Online Comment

Application H16-0863-26
Location 15 SHEEP MARKET SPALDING PE11 1BE
Proposal Internal alterations and change of use of ground floor to vape shop (Class E) and conversion of upper floors to form 2 self contained single person flats.

Name Imogen Colenutt, Assistant Conservation Officer
Address Council Offices The Hub Mareham Road LN9 6PH

PROPOSED
STREET ELEVATION | 1:100

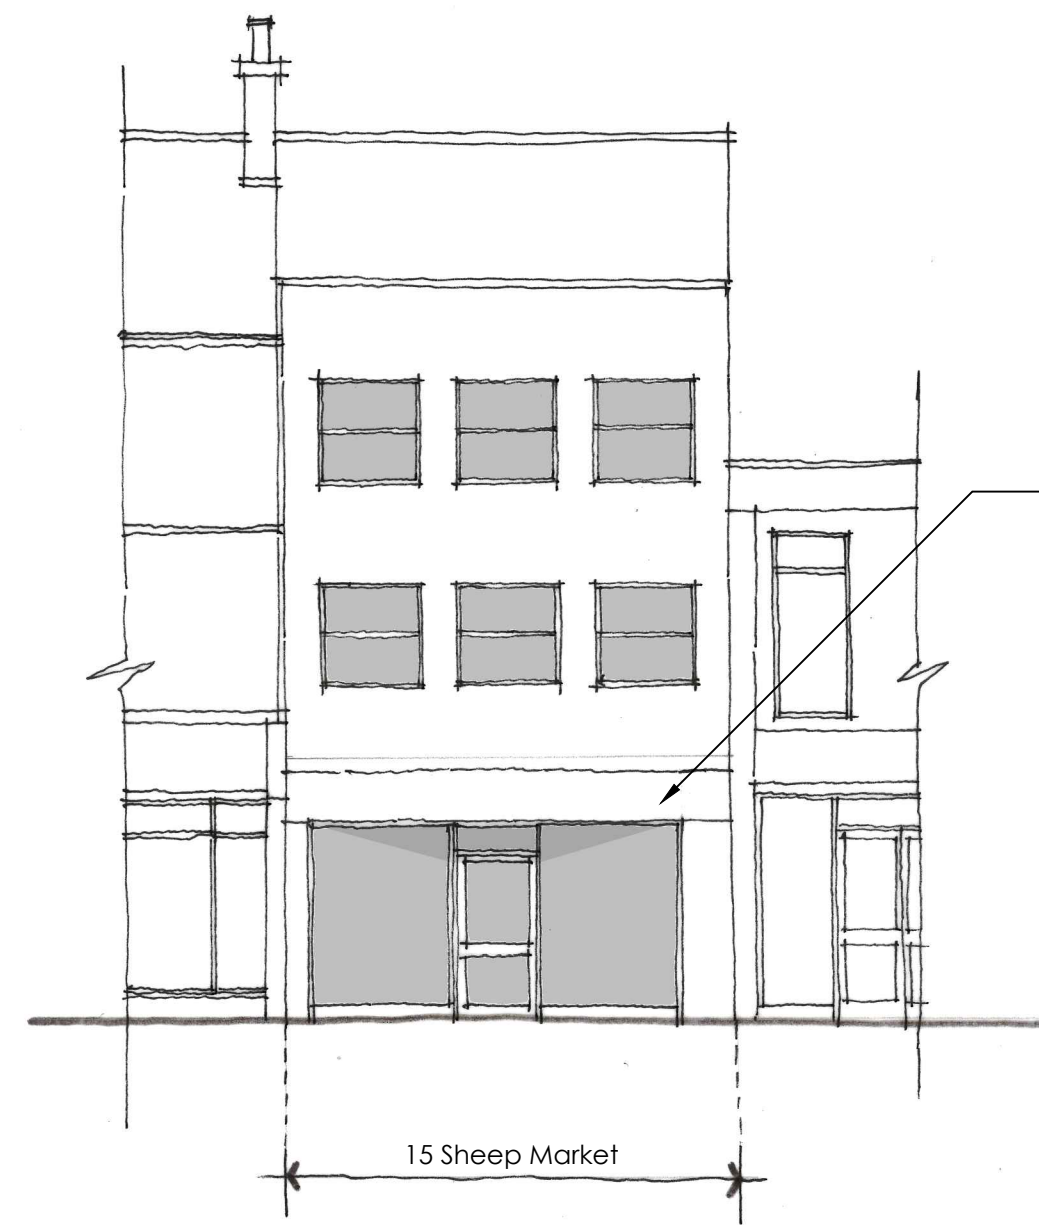
Whilst the submitted plans do not indicate any changes to the front elevation, it is recommended that an informative condition be attached insuring that any waste pipes, extract vents, flues, or similar services associated with the proposed first- and second-floor kitchens and bathrooms should not be installed on the front elevation. This is to ensure that the character and appearance of the Conservation Area is preserved.
